**KIRKLEES METROPOLITAN COUNCIL
INVESTMENT & REGENERATION SERVICE**

DELEGATED DECISION TO DETERMINE PLANNING APPLICATIONS

Reference No: 2017/62/92609/W

Site Address: 14, Howard Avenue, Lindley, Huddersfield, HD3 3DJ

DRG NO 1740-8A SCALE 1:50

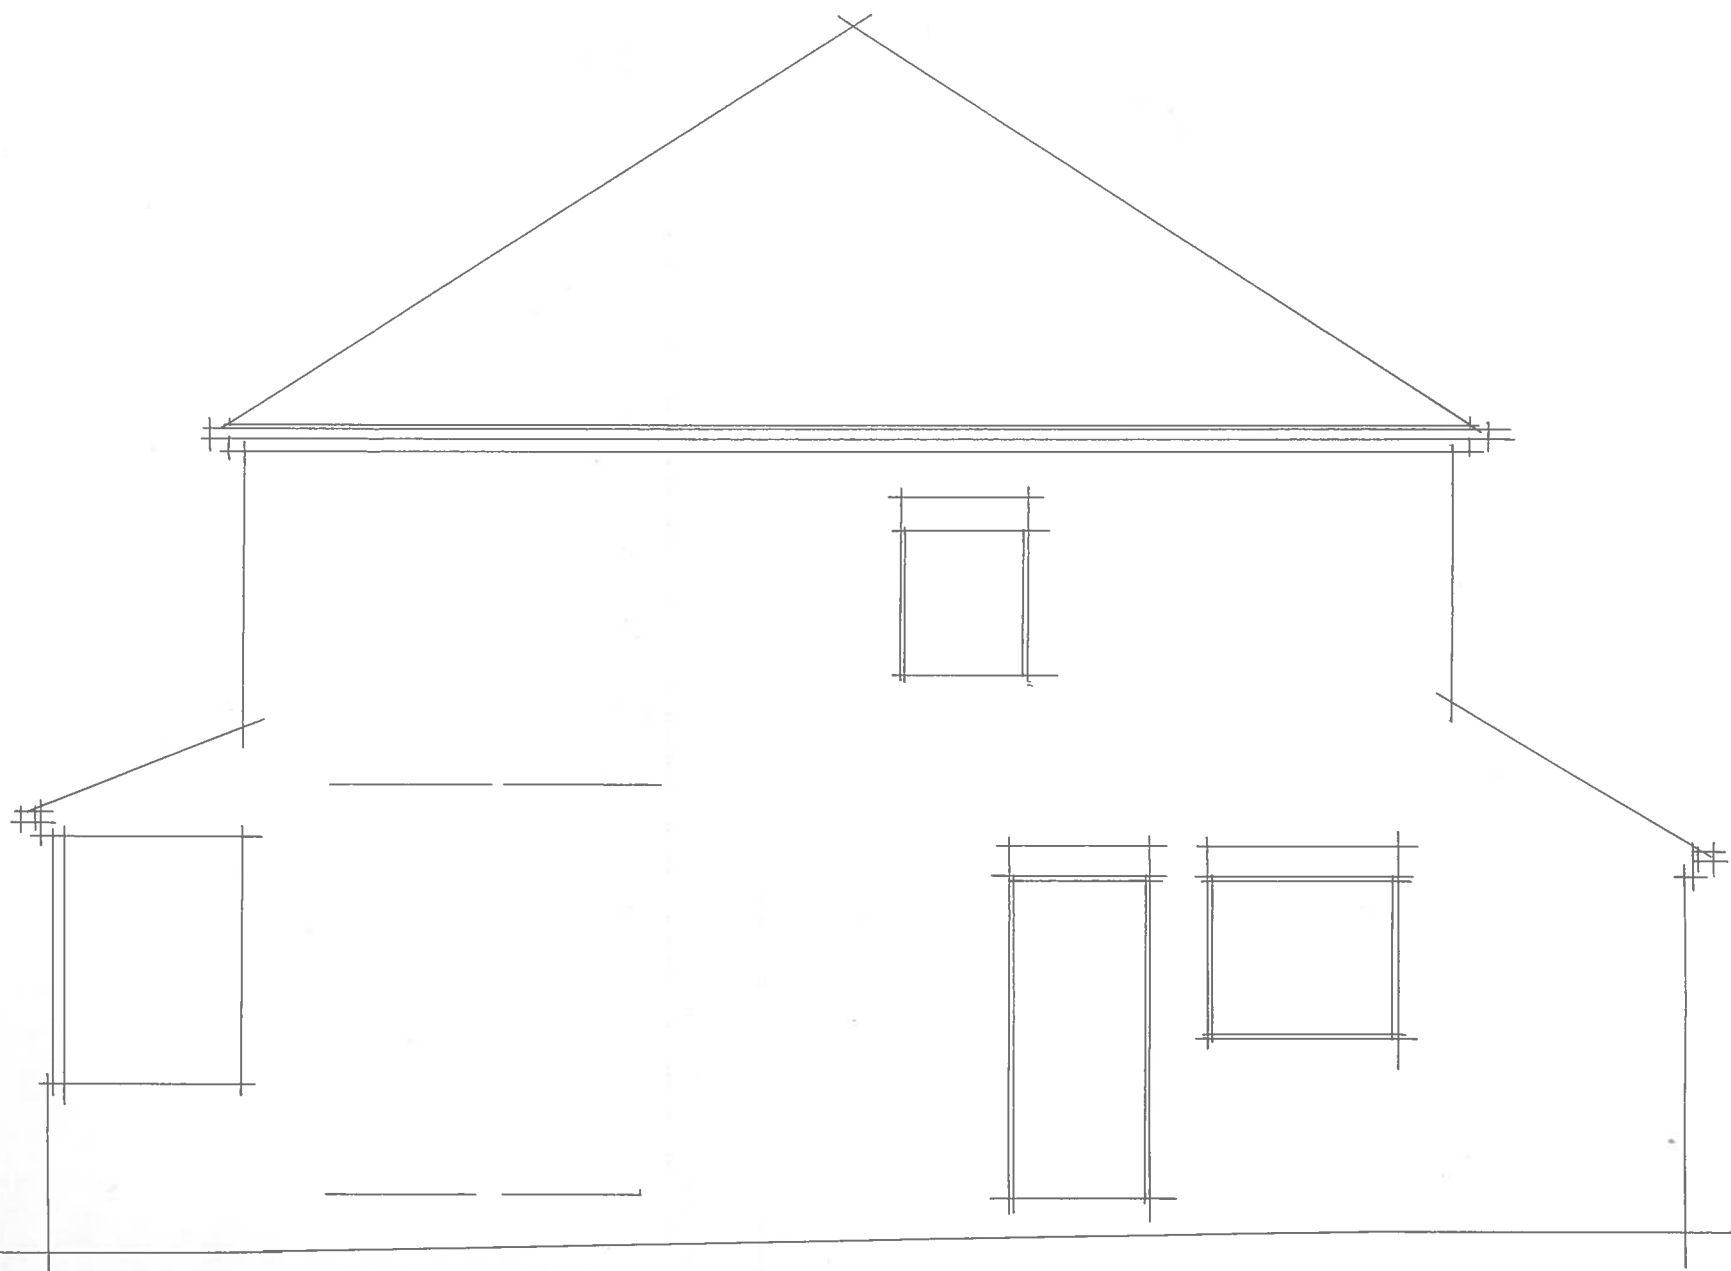
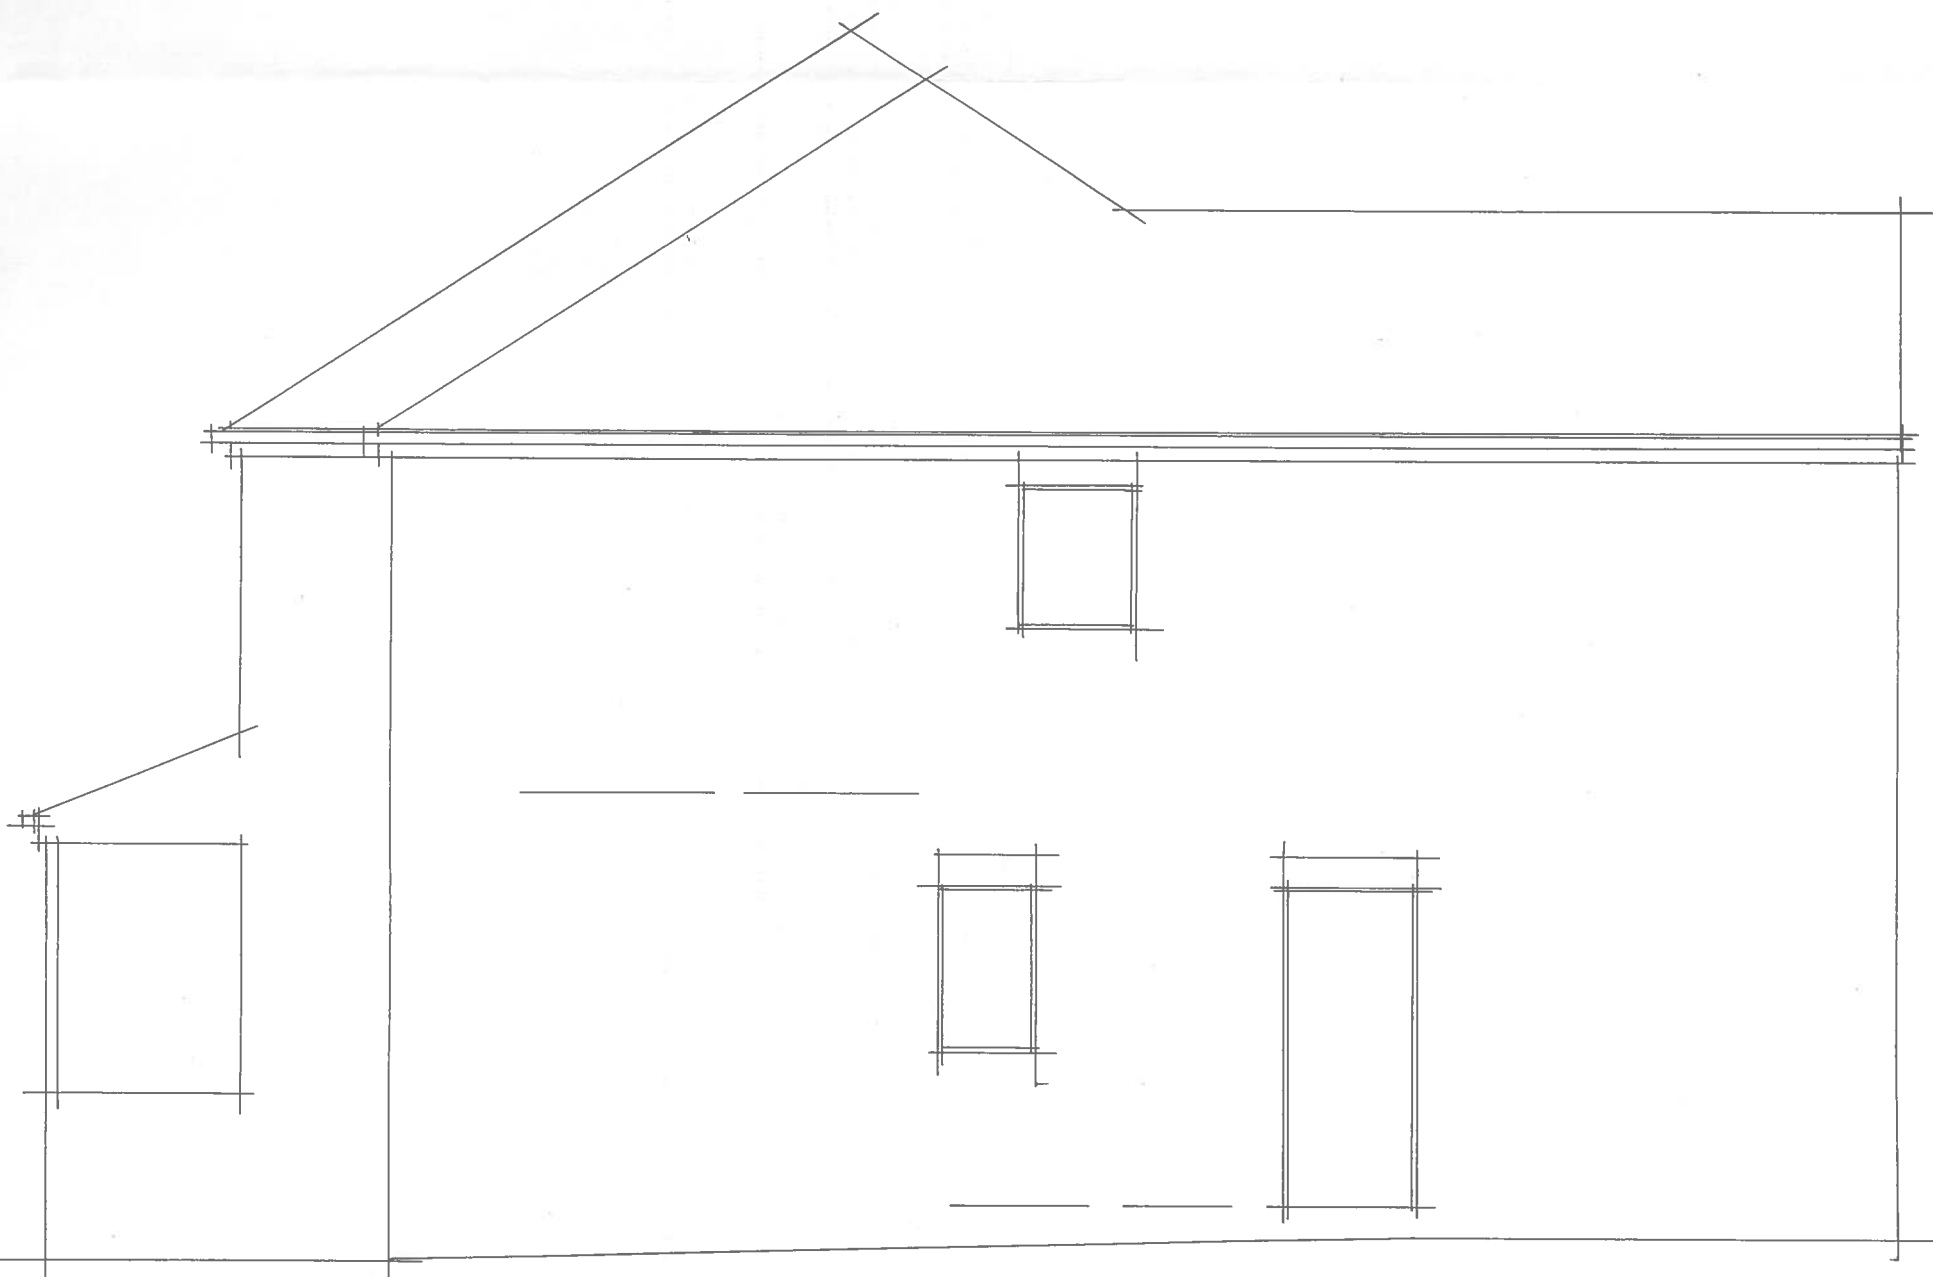
There would be no overlooking as there are no windows in the side elevations apart from a bathroom window which will be obscurely glazed. This window will be in a similar position to the neighbours bathroom window, resulting in them both being almost opposite one another. The neighbour has requested the bathroom to be relocated to the rear of the property which is an unreasonable request, however this window could be conditioned to be a top opening only as well as being obscurely glazed which is considered to sufficiently mitigate this concern.

At the rear of the property the extension would project 3m albeit 2-storey along the boundary with No 12A, however this additional projection will bring the building in line with the neighbour's property creating no additional overshadowing. However there is a landing window in the neighbour's property located centrally to the side elevation, to help light within the hallway which is not a habitable room window, the neighbour has requested this elevation to be painted white or a light reflective surface. Given the mix of styles and material palette within the area the side elevation can be conditioned to be a light stone colour.

- Windows in the side elevation should be obscurely glazed.

5. Notwithstanding the details on the submitted plans, the side elevation shall be either block work and rendered with a light cream/stone colour or the brickwork painted a light cream/stone colour.

7. The bathroom window in the side elevation, shall be obscurely glazed (minimum grade 4) and be a top opener, before the extension is first brought into use. Notwithstanding the provisions of section 55(2) (a) (ii) of the Town and Country Planning Act 1990 and the Town and Country Planning (General Permitted Development) Order 2015 (or any order revoking or re-enacting that Act or Order with or without modification) this window shall thereafter be so retained obscure glazed and a top opener.
